**EP/53/21/L**

*Preston Hall, Flat 3 The Street East Preston BN16 1HU*

*Listed building consent for original bathroom relocated & dining room formed, fan installed in bathroom, en-suite installed in bedroom 1 & fan installed, new doorway into bedroom 1 & existing door way blocked up, internal timber stud wall/corridor removed & kitchen enlarged and internal lobby formed.*

AS BUILT EXISTING GROUND FLOOR PLAN 1:100 - MAY 2021

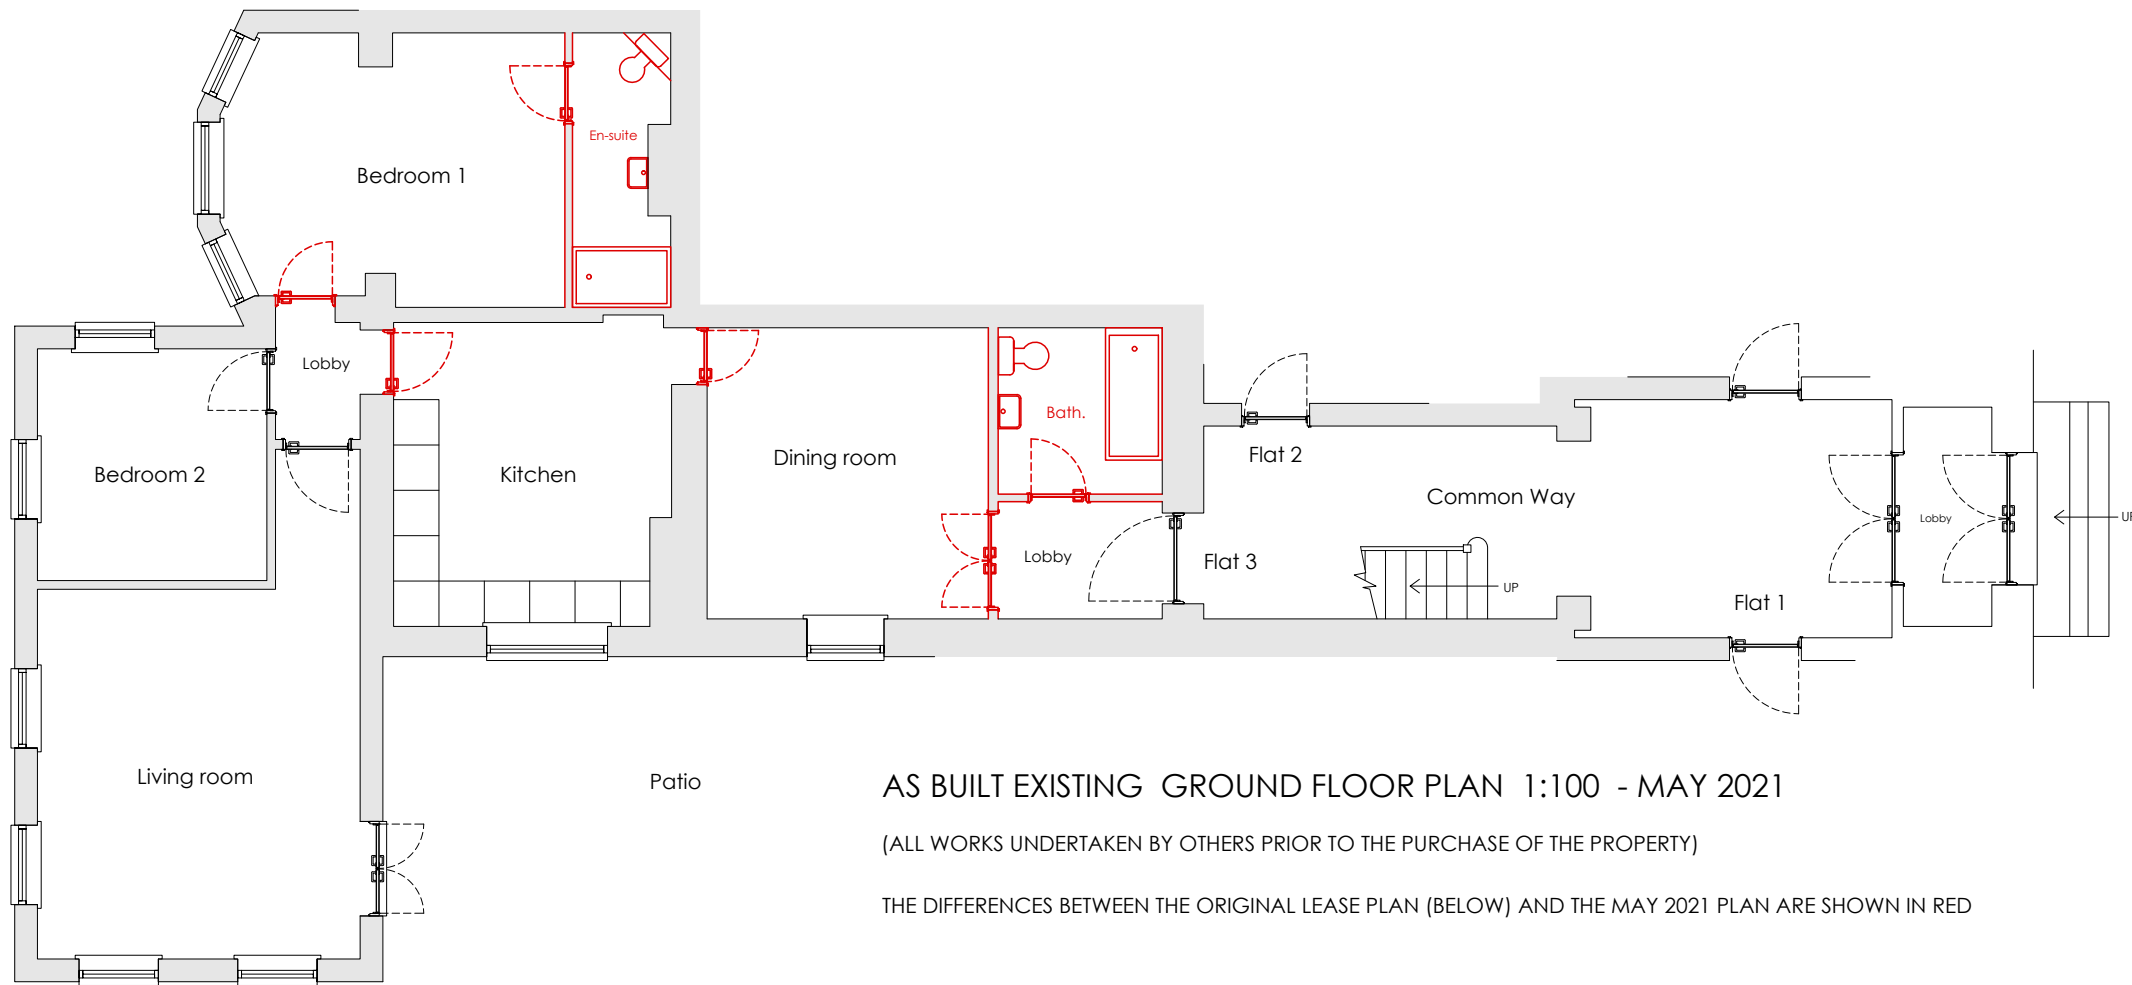
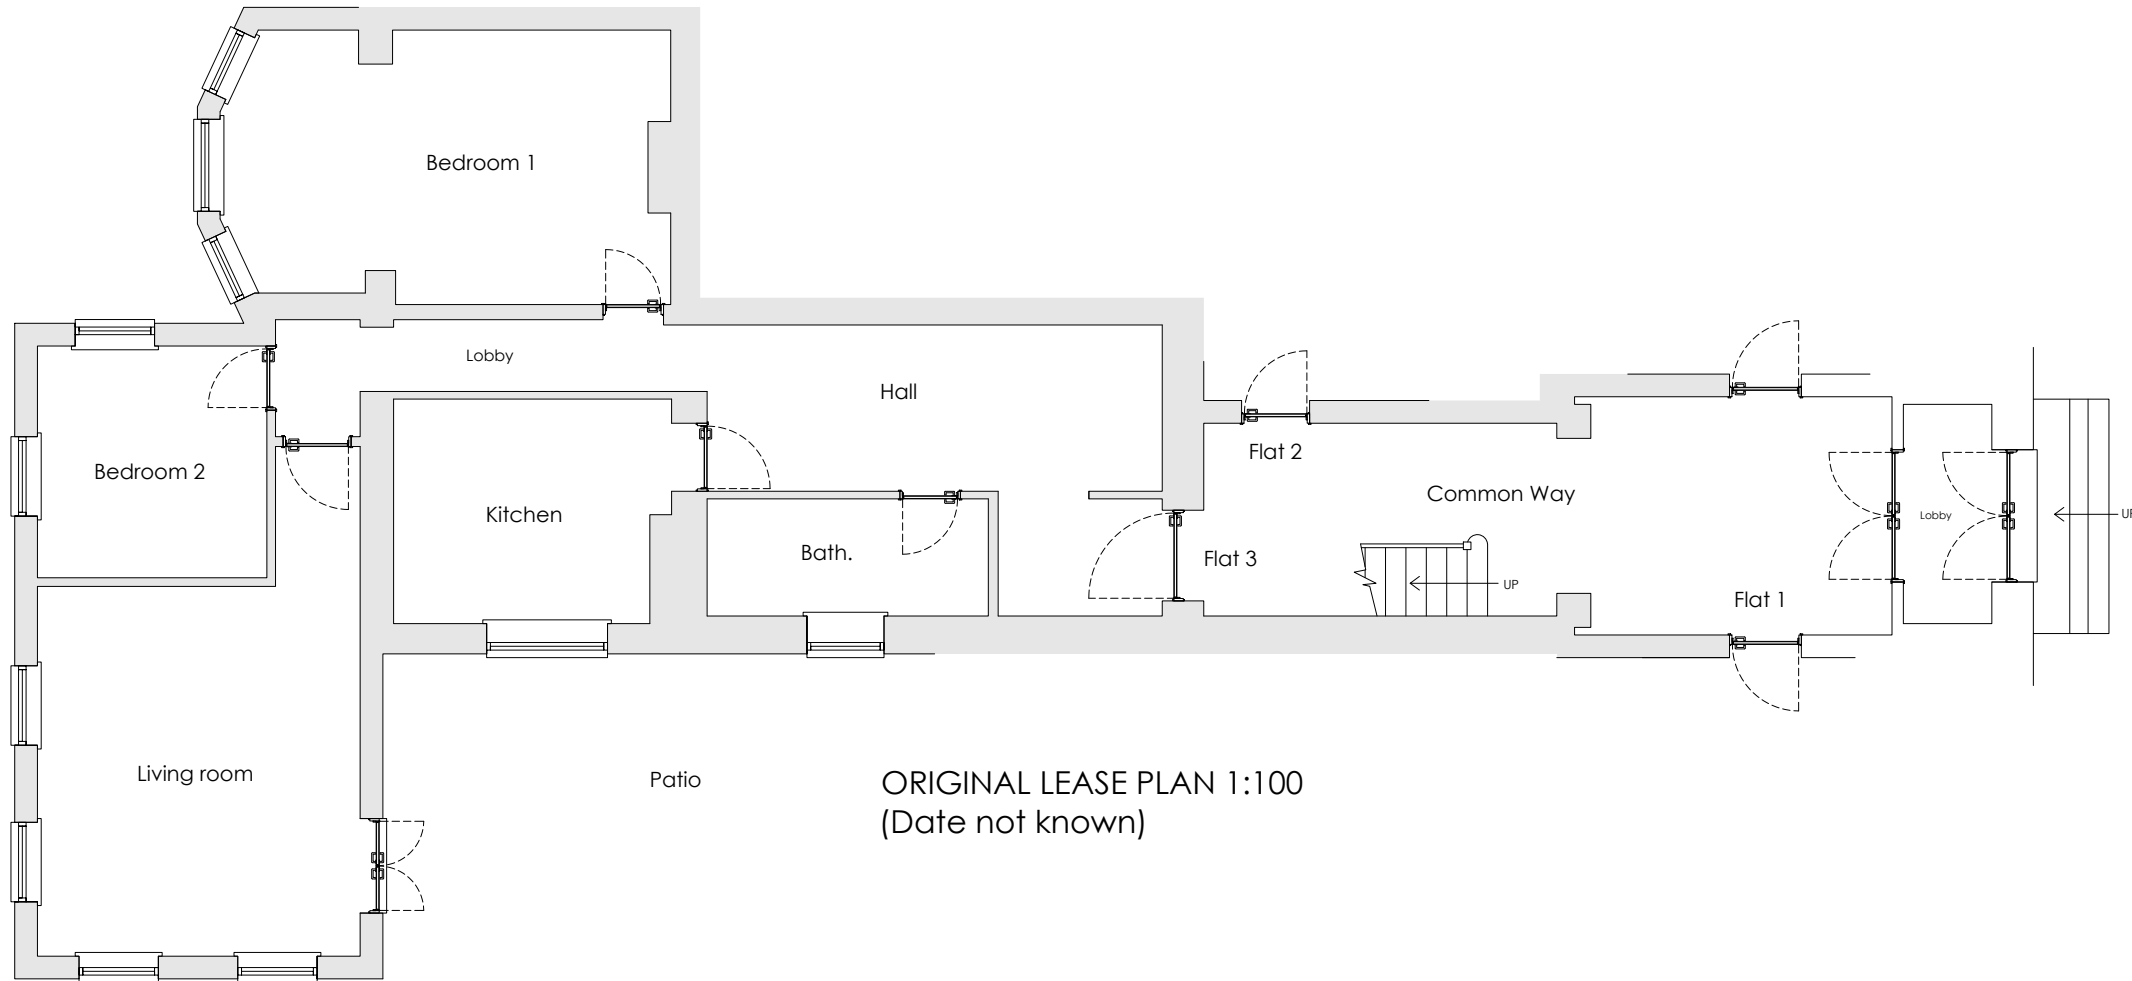
It would appear that a previous owner of the flat has undertaken various works to it without the necessary consents. These would appear to relate to the relocation of the bathroom, creation of a lobby area and dining room, the installation of an en-suite, creation of a new doorway, blocking up an existing doorway and the removal of a modern timber stud wall. These works predominantly affect modern fabric and are not considered to affect the significance of the building, which has already been impacted as a result of the conversion. They are therefore considered to be acceptable, in this particular instance.
